Meeting note

| Project name | Lake Lothing Third Crossing |
| Meeting objectives | Draft document feedback meeting |

Draft documents review

Drawing file: TR010023 / TR010023-001034-Suffolk County Council - Environmental Statement Volume 3 Appendix 18A - Flood Risk Assessment Annex C Figures 3.1 and 6.1.pdf

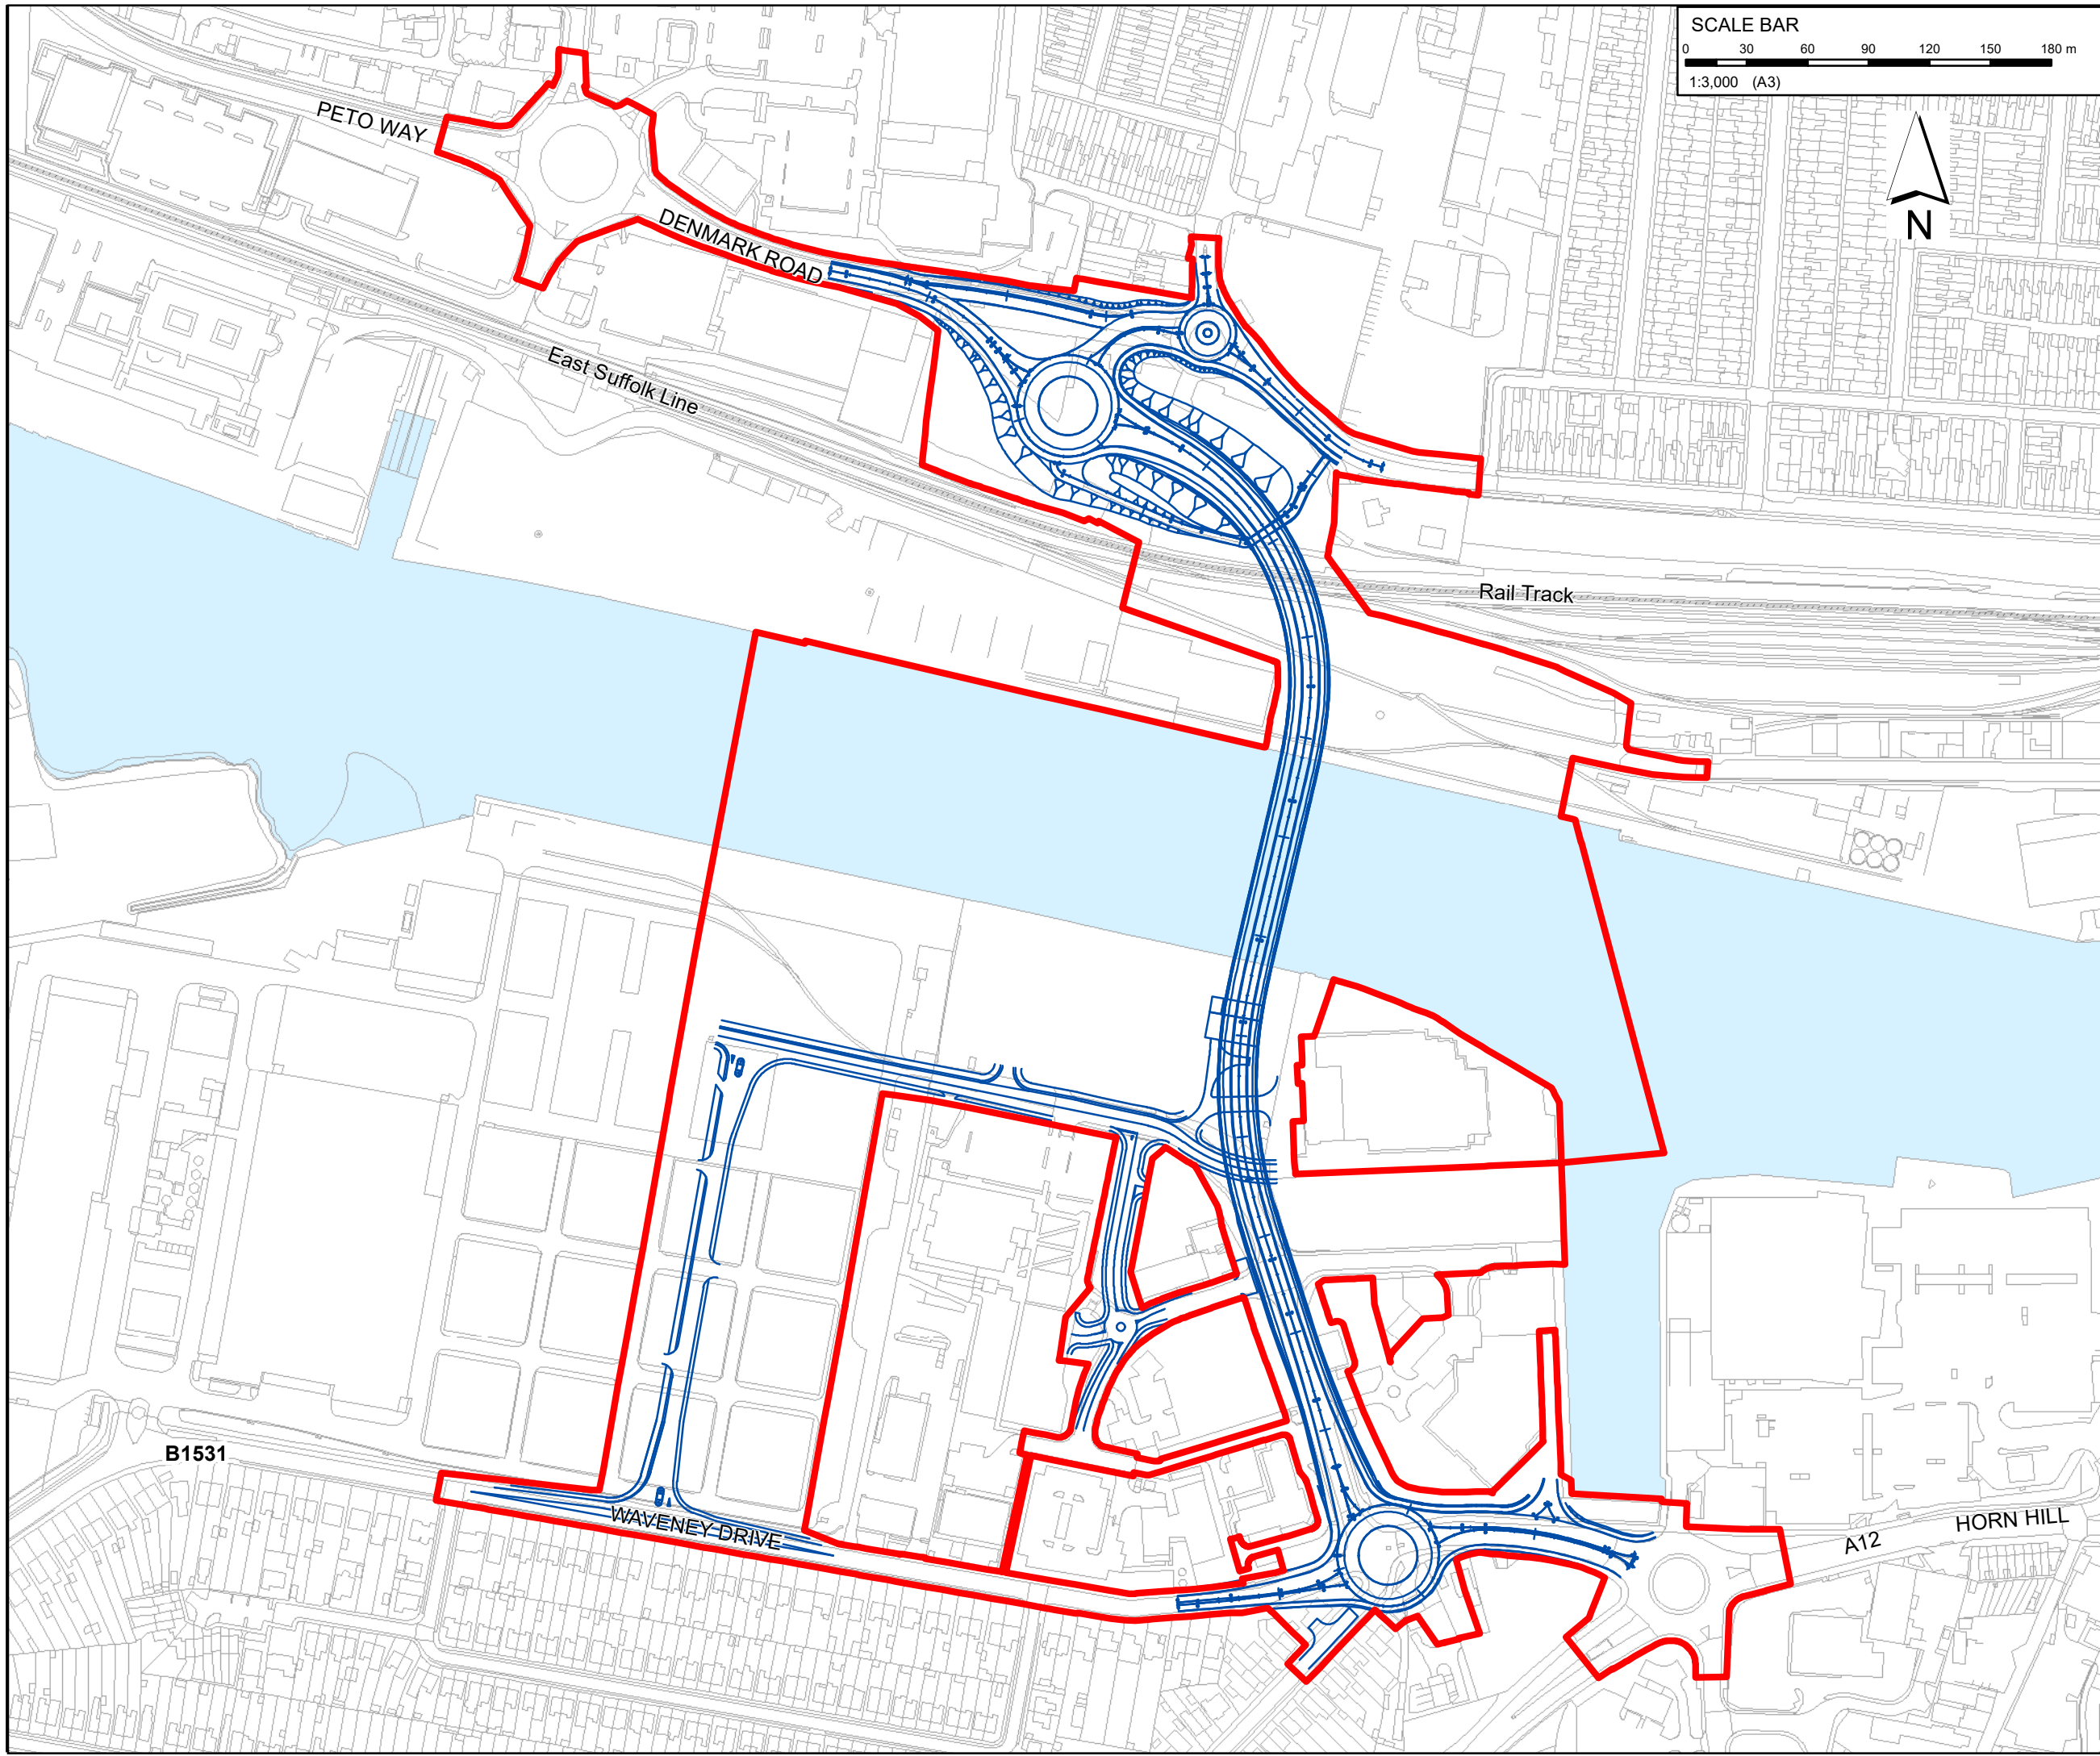
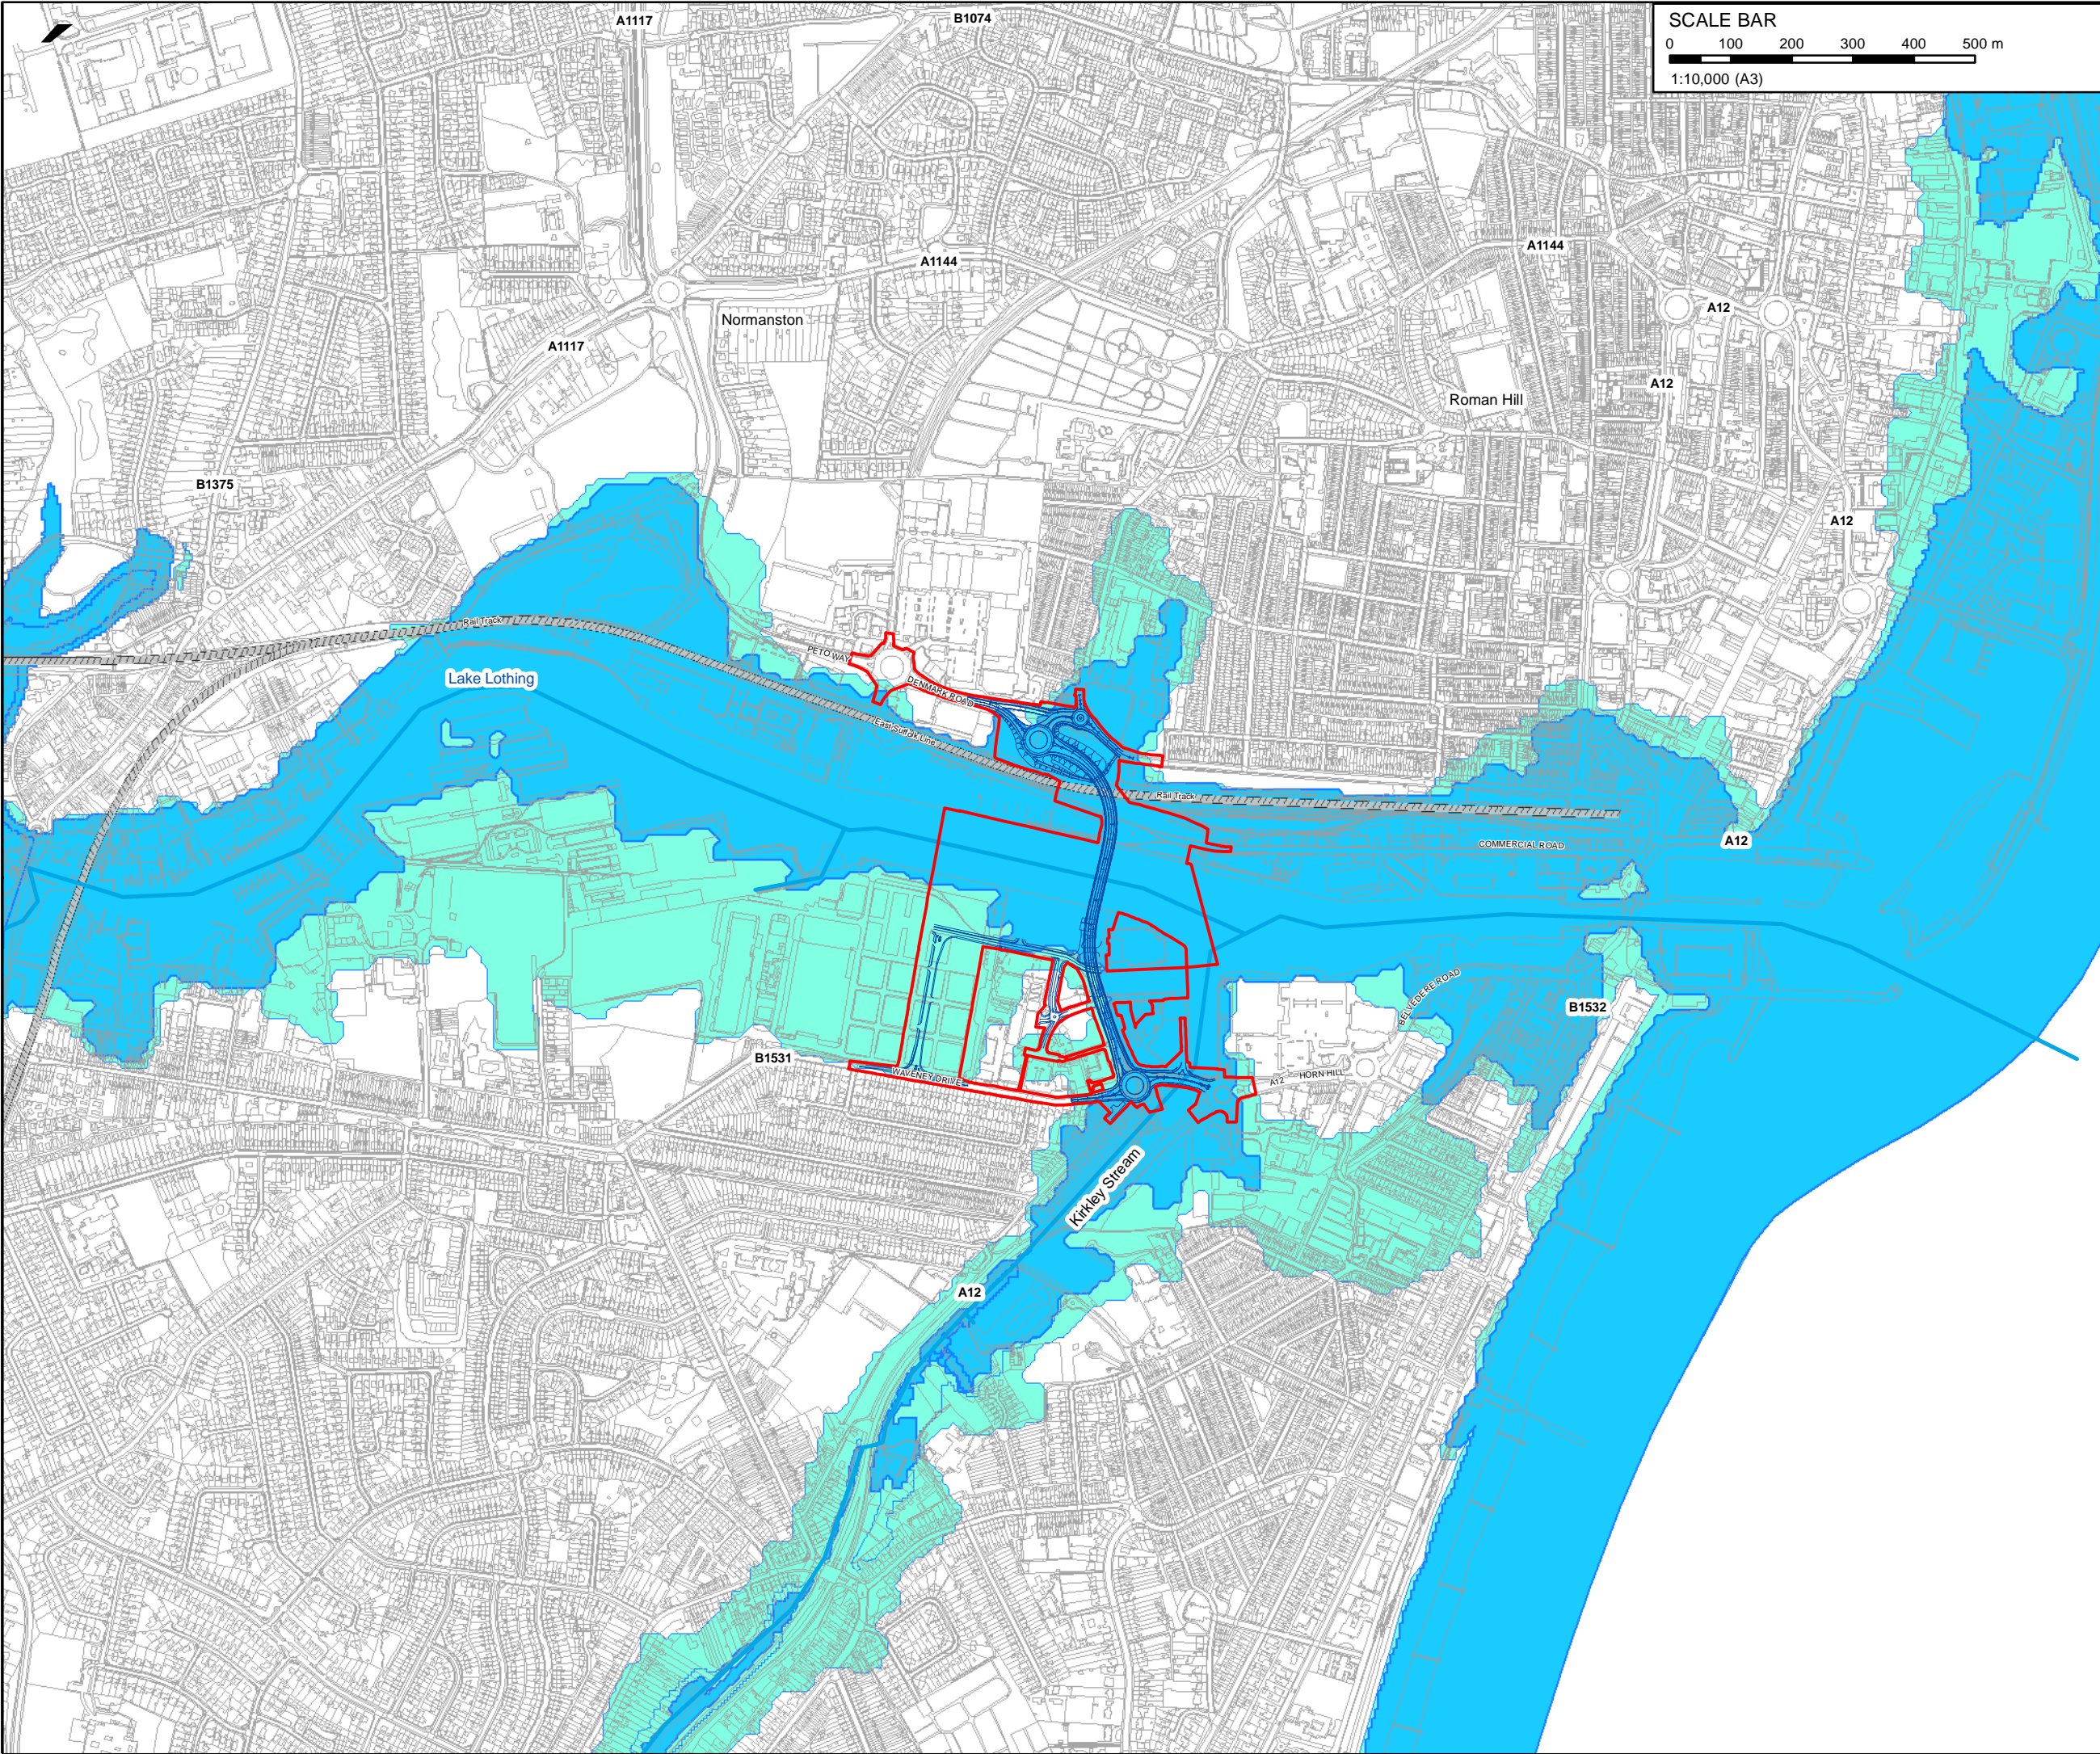
| Figure 1.1 and 6.1 | These have not been included in the report. |
